CITY OF ALBUQUERQUE

RE: **La Cuentista Subdivision Unit 2**
Request for Pad Certifications
Lots 2-6, Block 3; Lots 5 & 11-13, Block 7 – Accepted
Lot 11, Block 6 – Not Accepted
Grading Plan Stamp Date: 11/16/17
Certification Dated: 10/5/18
Hydrology File: D10D002B

Drawing Sheet
5 OF 513 OF 32

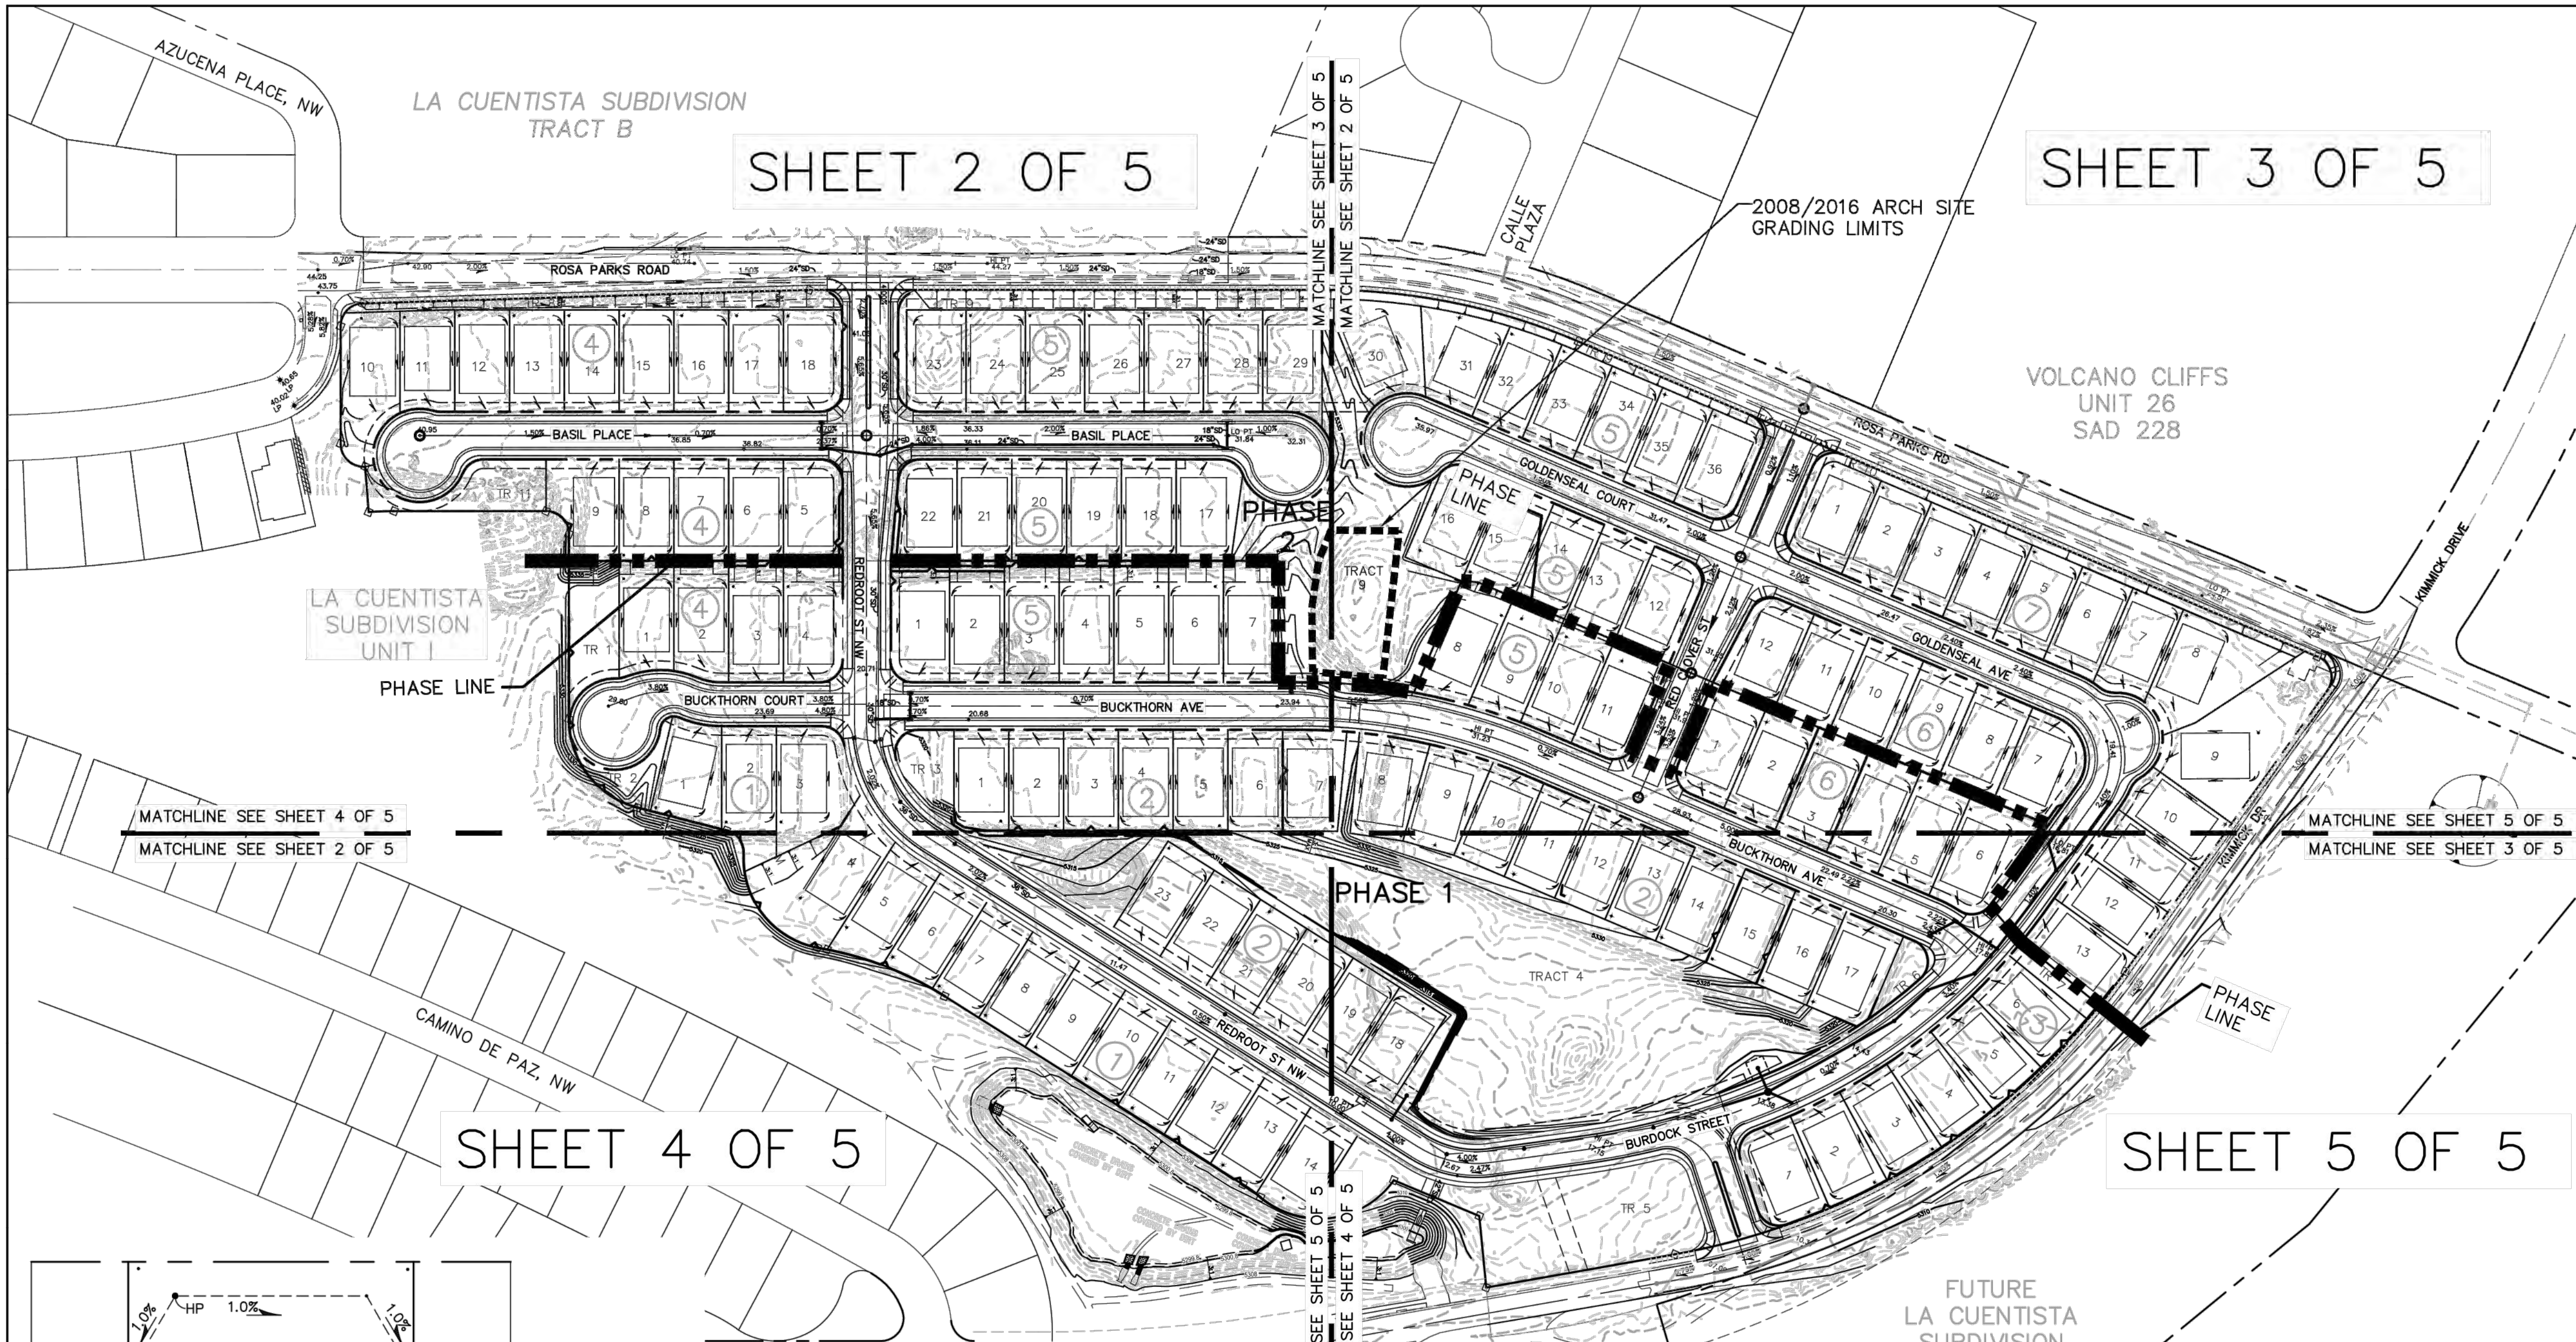
1. Lot 11, Block 6. Remove the dirt piles placed on the pad; there is also a small section of retaining wall abutting this lot that should be built.
